RE: FW: Taco Bell, Washington Avenue Portland maine

The following revision was made to the Site Plans dated 7/6/16 to meet the Site Plan Conditions of Approval.

The additional list of revisions to the Site Plans dated 7/6/16, below, were made to clarify the site plans for the Contractor's use during construction.

Not Approved for Construction  
Drawing Title  
**Layout & Materials**  
Drawing Number

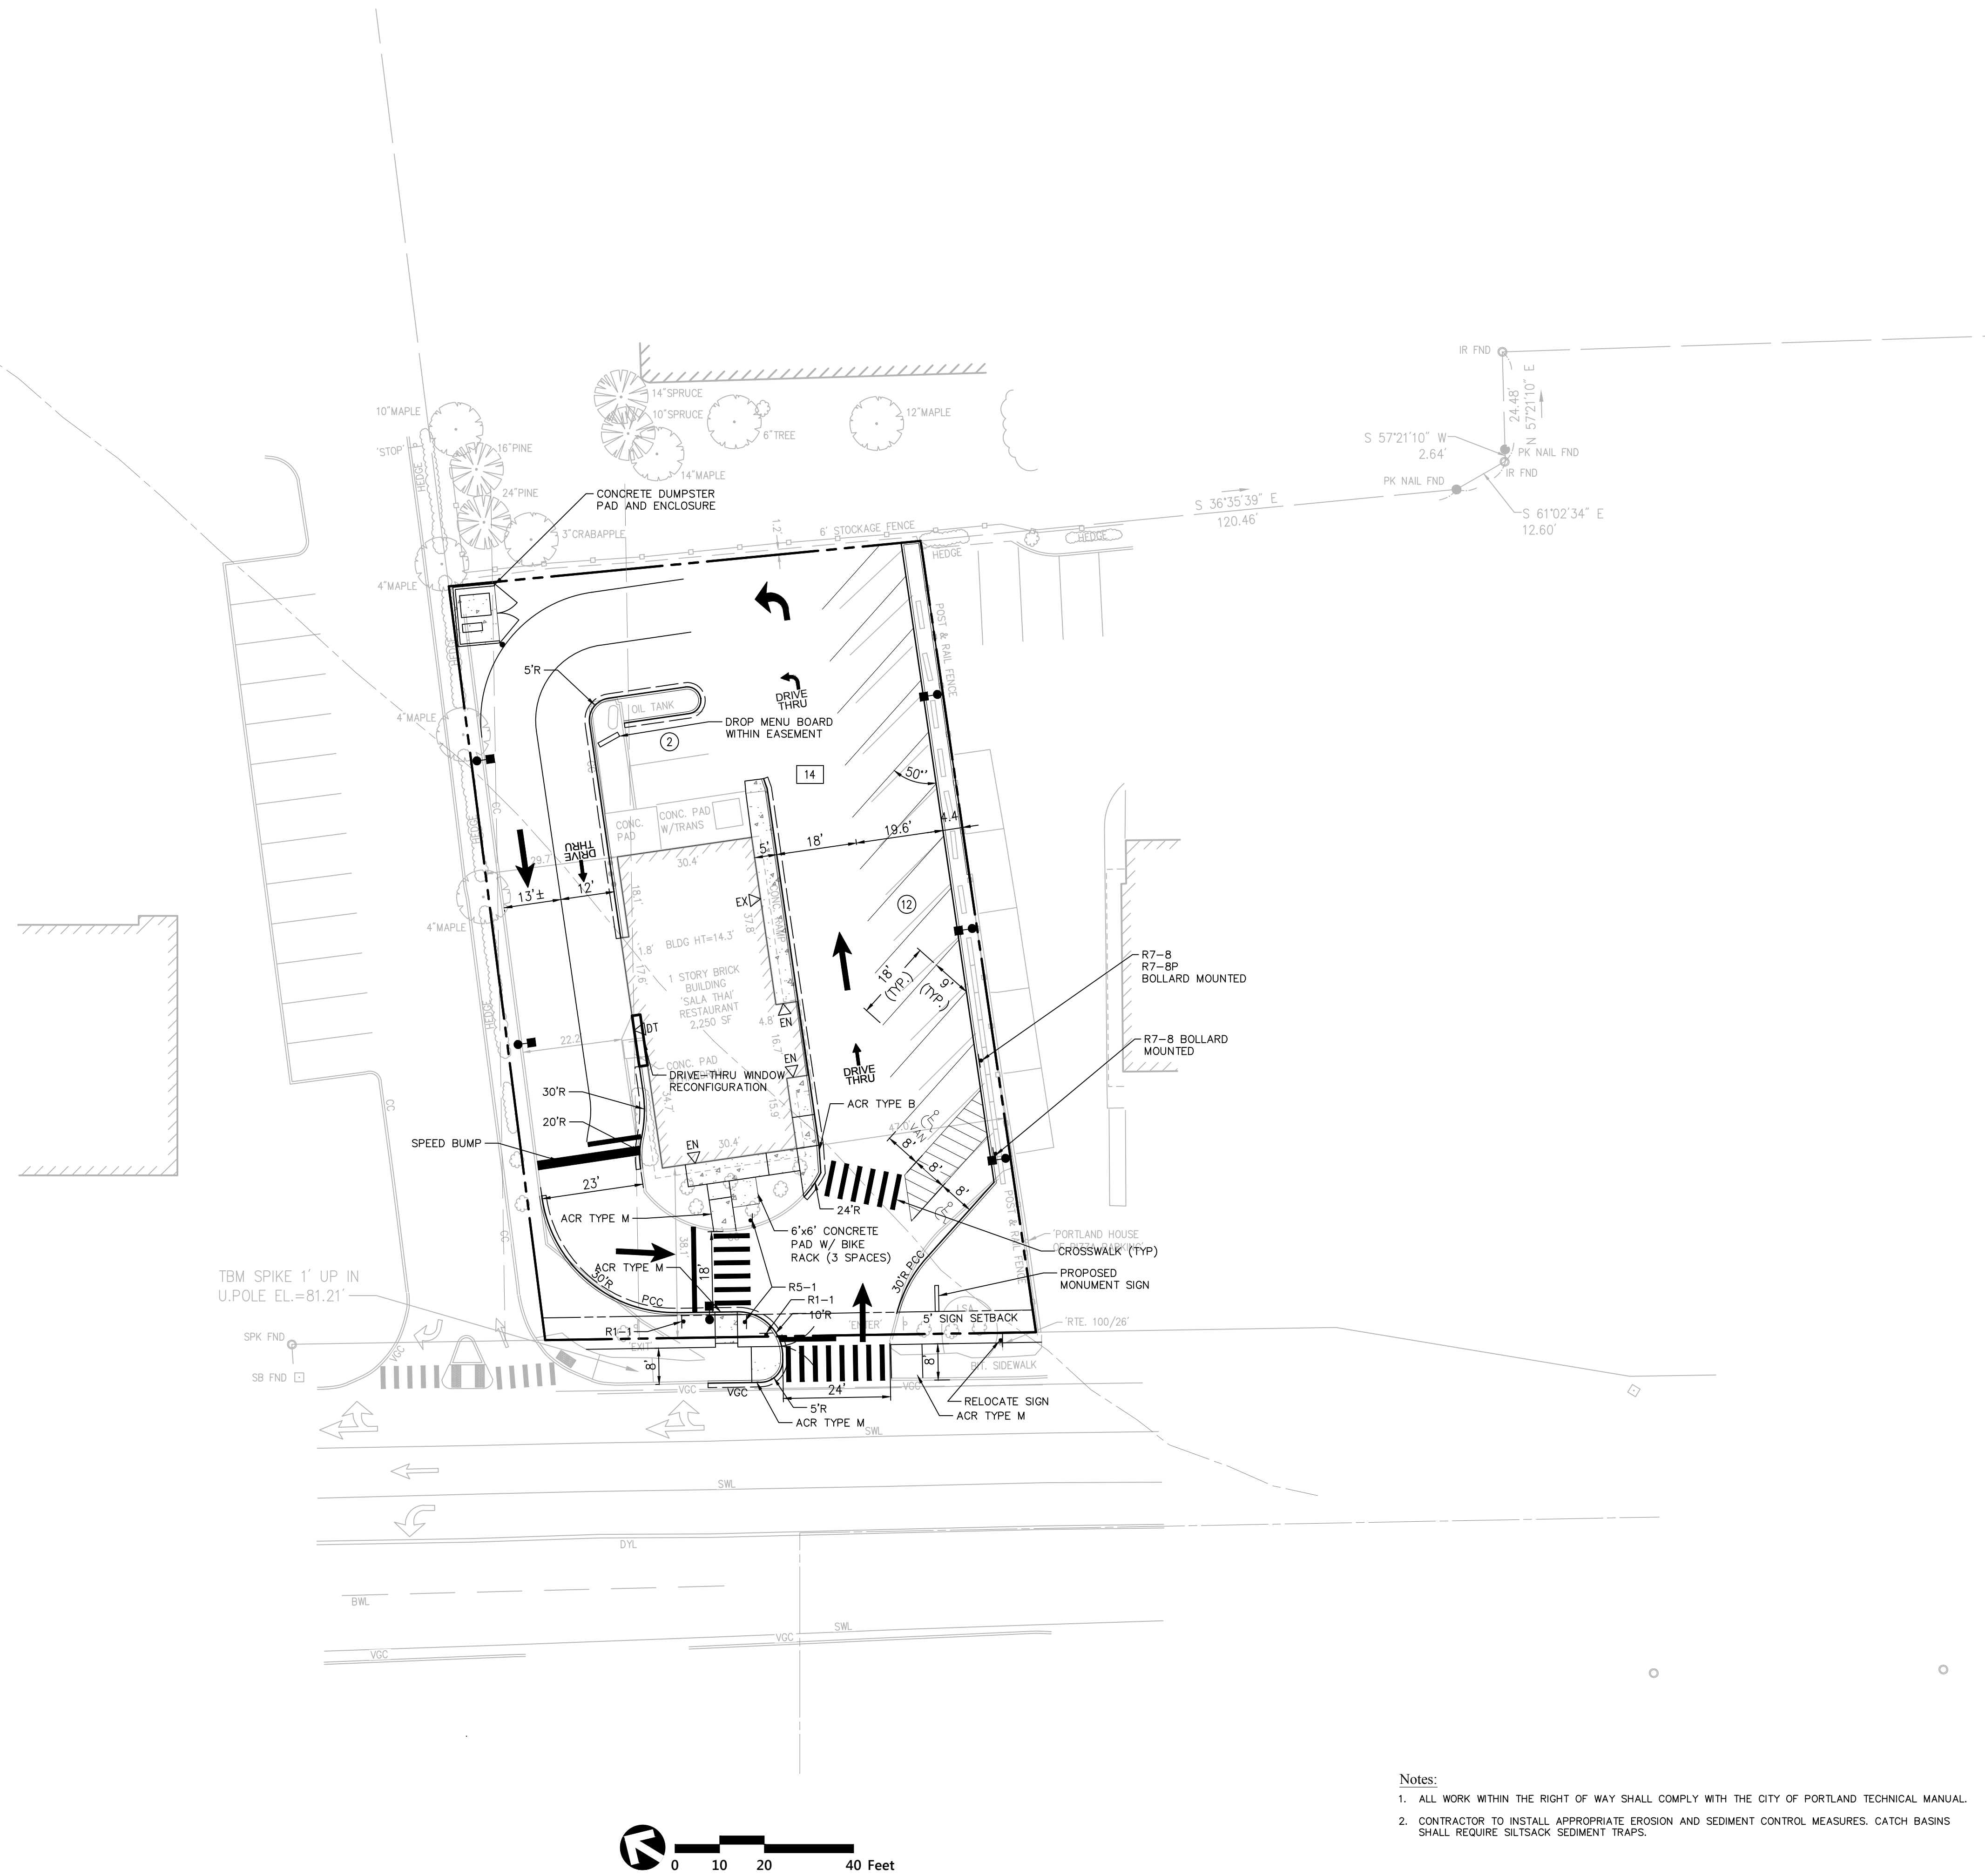
- Notes added to clarify materials and match details (ie. Bollard, Stop Bar, Concrete Sidewalk, A, etc.)
- Demolition notes for clarification (ie. R&D curb under dumpster pad)
- Notes to clarify ownership of work to be provided (ie. See Architectural Plans)
- Labels for pavement markings (ie. "SWLL", etc.)
- Dimensions added for clarification during construction (ie. dimensions on existing 2 parking spaces to remain)
- Arrows removed (during permitting they depict circulation on-site, and excessive ones removed so they are not painted as final pavement markings)
- Sawcut line revised to include trenching required for the grease trap and piping as well as removal of existing curb
- No changes occurred to the layout of the 5/4/16 sidewalks or parking lot.
